Waterside House, Uxbridge

Class 0 Change of Use Application

Report Title: Class 0 Change of Use Application

Report Ref: P931

Project Title: WATERSIDE HOUSE, UXBRIDGE
Project Ref: 1153
Status: PLANNING
Scale: 1:100 / A1
Sheet Title: GA PROPOSED GROUND FLOOR PLAN
Sheet Ref: P130 / 0

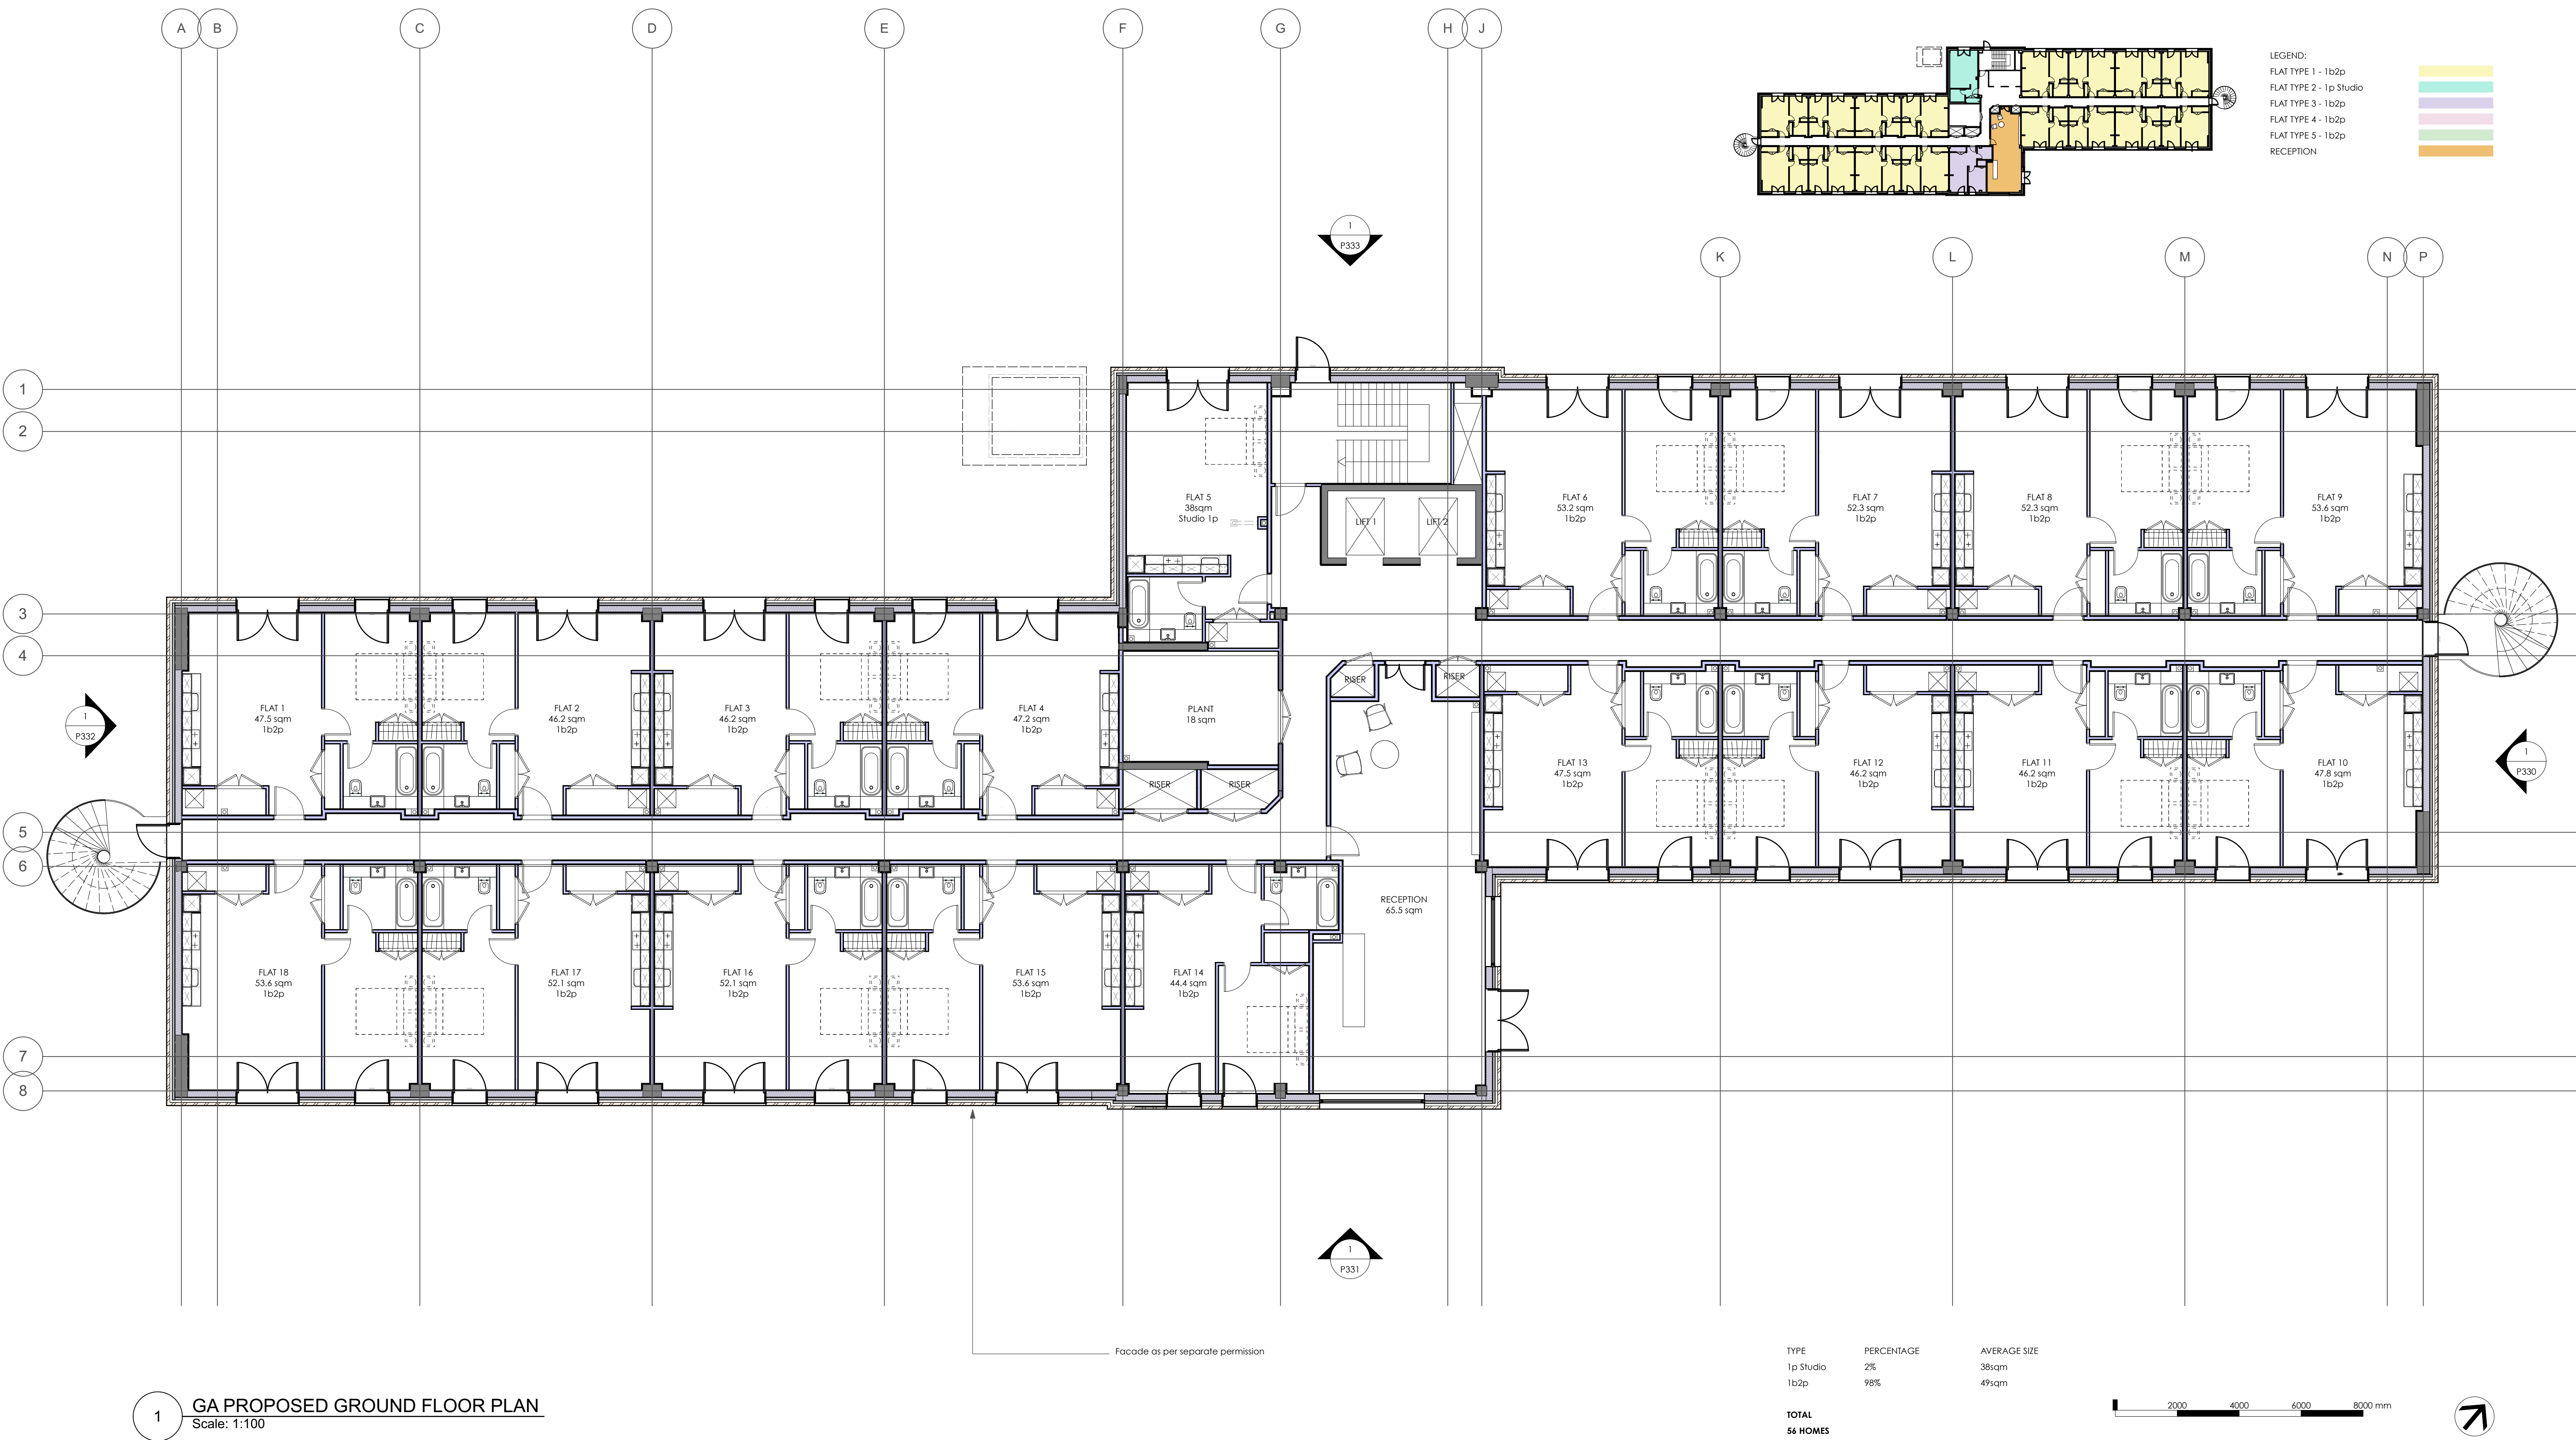
- The arrangement of apartments on the ground, floors, is consistent with the consented scheme where the predominant changes occur along the internal wall of apartments where the width of the corridor has narrowed slightly to allow for generally 1200mm clear wall-to-wall, with passing spaces 1500mm in width. The naming conventions of the individual apartments is consistent with the NDSS and the previous application.

- Minor rationalisation of the ground floor reception and 1b2p apartment adjacent where the size and location of the existing structure is now better understood following strip out of the existing building.

- Minor internal modifications of apartments to create improved, more open plan living accommodation, with better access to storage.
- Rationalised arrangement of bathrooms and coordination of services between the ground and fourth floors.

- Modification of Apartment 5 (left-hand side of the stair core) owing to the position of the existing primary structural fin walls which cannot be removed.

- To the north and east elevations, where windows were previously not identified on plan these are now captured.
- Revised riser positions and sizes following MEP advice.

Project Title: WATERSIDE HOUSE, UXBRIDGE
Project Ref: 1153
Status: PLANNING
Scale: 1:100 / A1
Sheet Title: GA PROPOSED SECOND FLOOR PLAN
Sheet Ref: P132 / 0

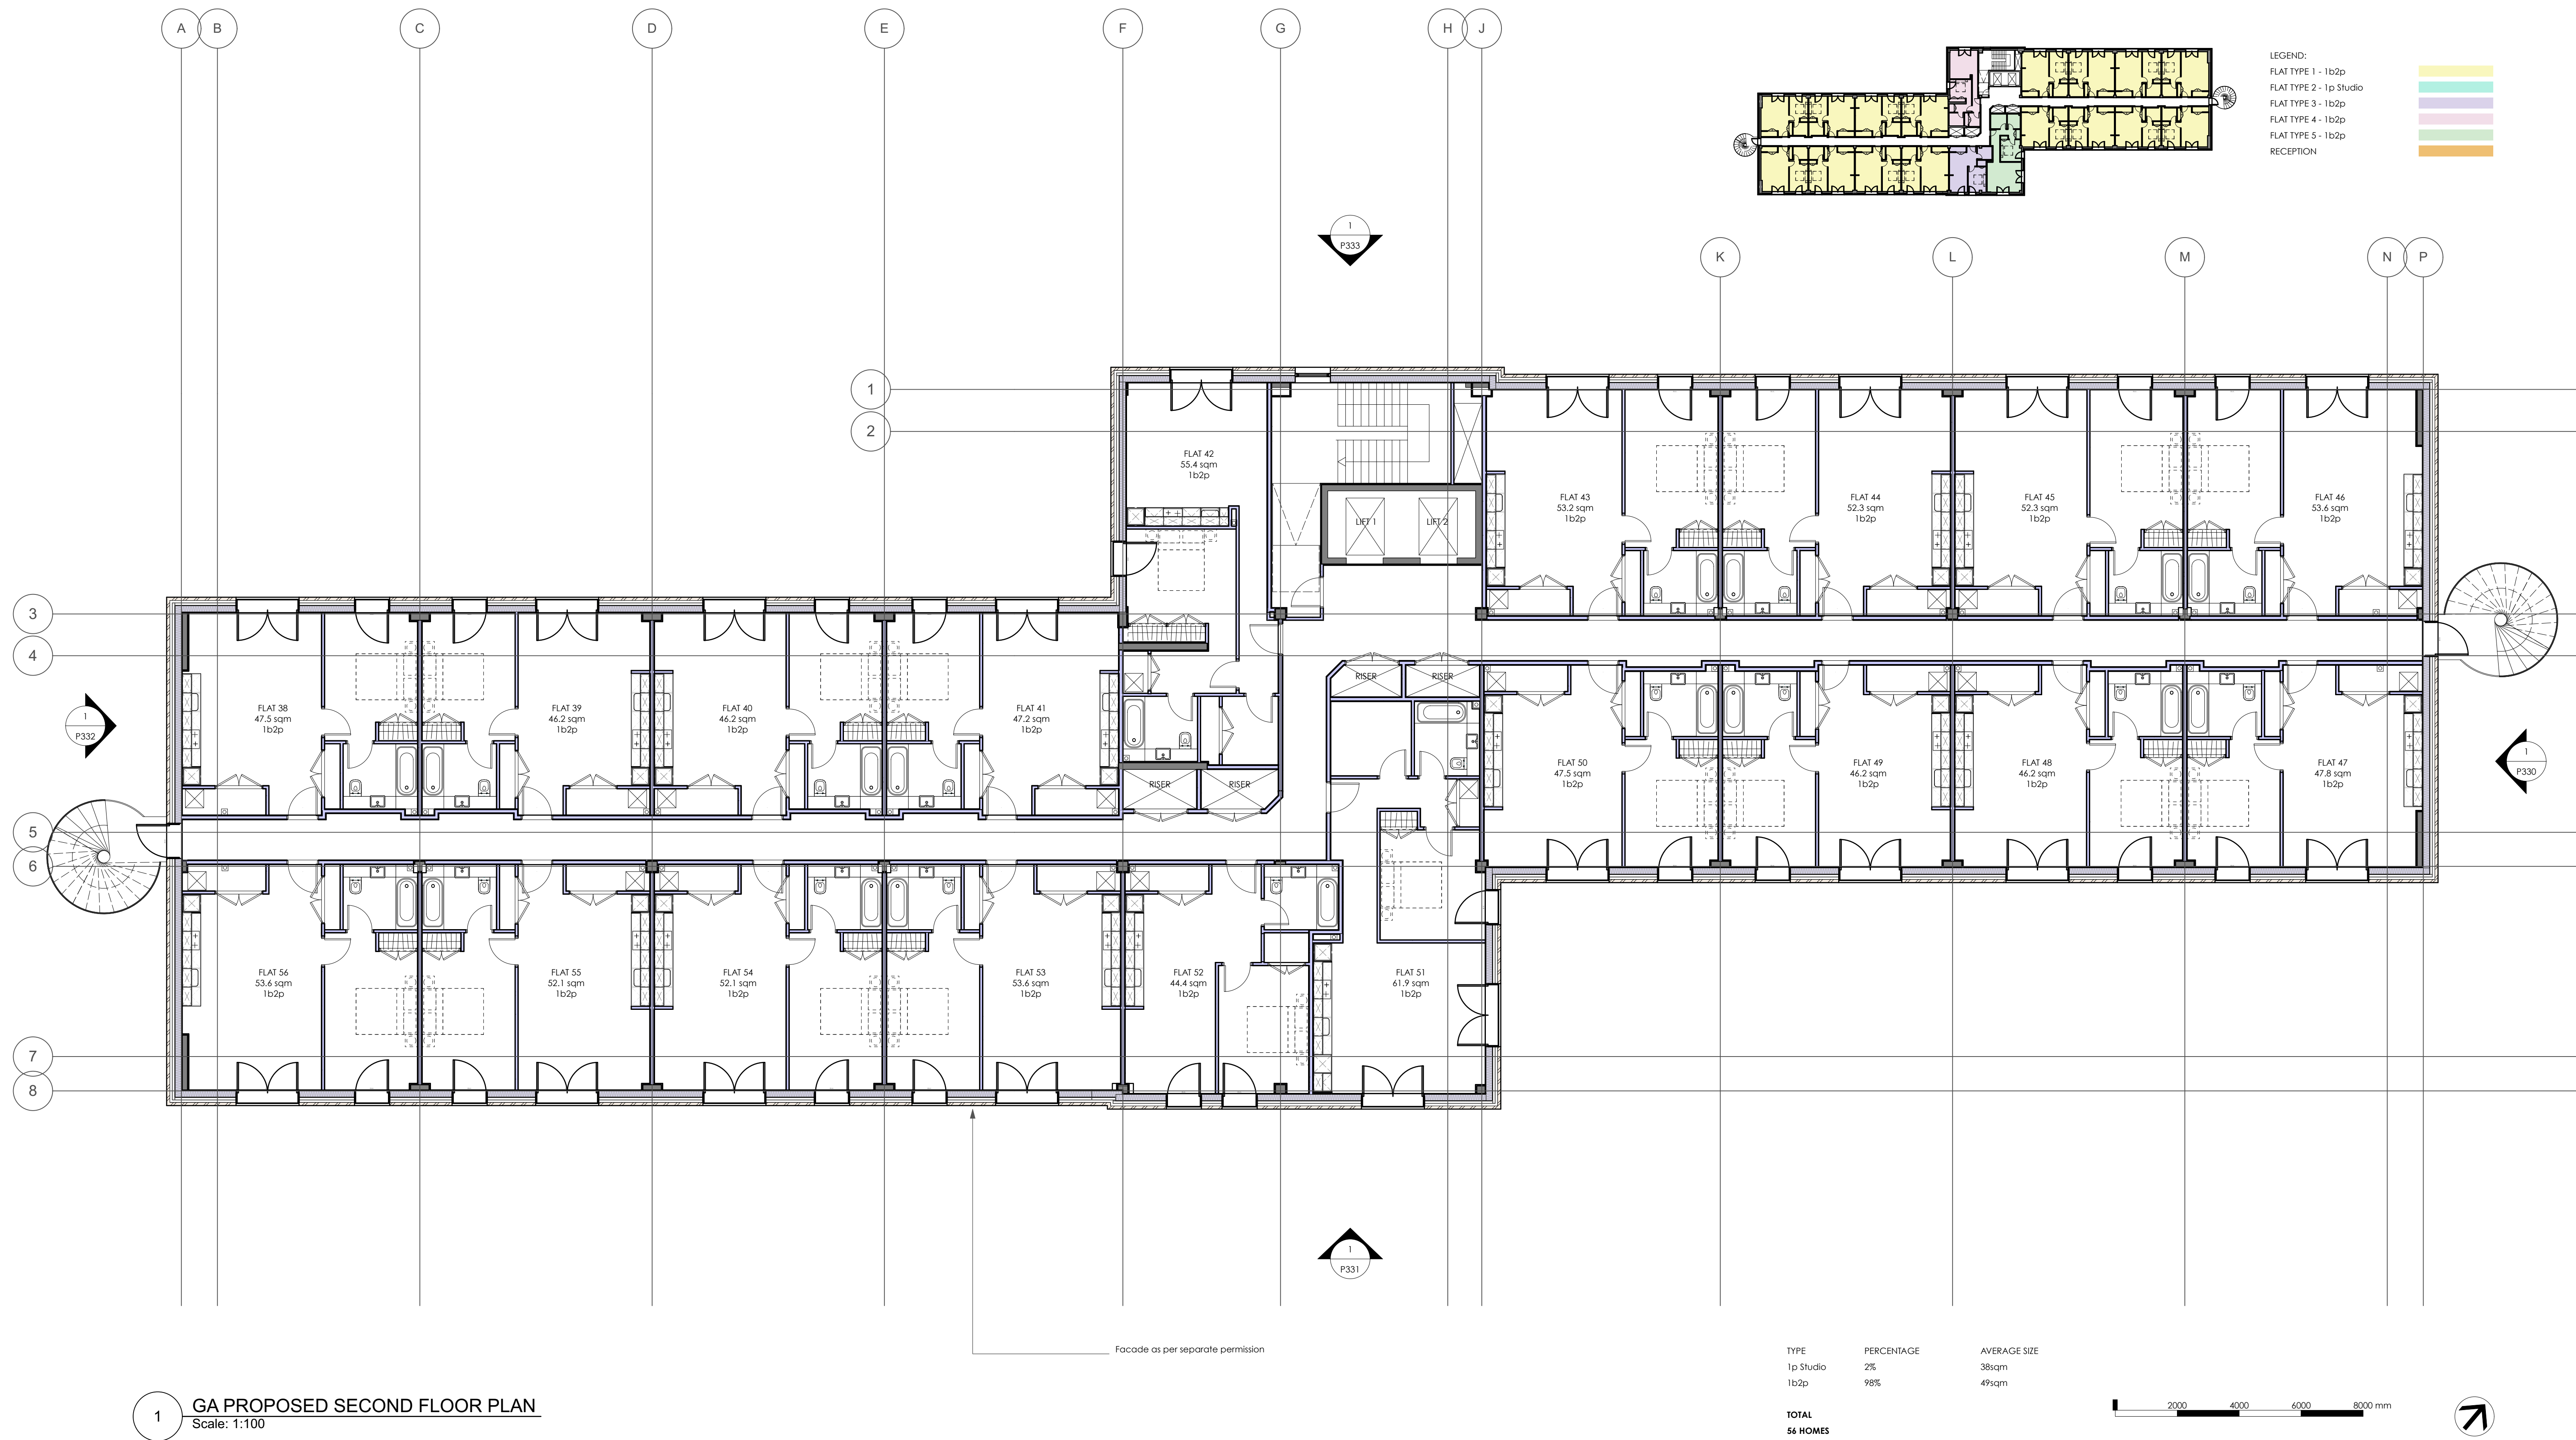
- The arrangement of apartments on the first and second floors are consistent with the consented scheme where the predominant changes occur along the internal wall of apartments where the width of the corridor has narrowed slightly to allow for generally 1200mm clear wall-to-wall, with passing spaces 1500mm in width. The naming conventions of the individual apartments is consistent with the NDSS and the previous application.

- Inclusion of a localised ramp adjacent to the lift core and between the stair landing and the lift lobby. The ramp allows for level differences between the slab and stair landing.

- Minor internal modifications of apartments to create improved, more open plan living accommodation, with better access to storage.
- Rationalised arrangement of bathrooms and coordination of services between the ground and fourth floors.

- Modification of Apartment 23/42 (left-hand side of the stair core) owing to the position of the existing primary structural fin walls which cannot be removed.

- To the north and east elevations, where windows where previously not identified on plan these are now captured.
- Inclusion of risers where these were previously missed of the arrangement plan.

- Modification of the internal layout of apartment 32/51, following changes to the arrangement of the service risers.
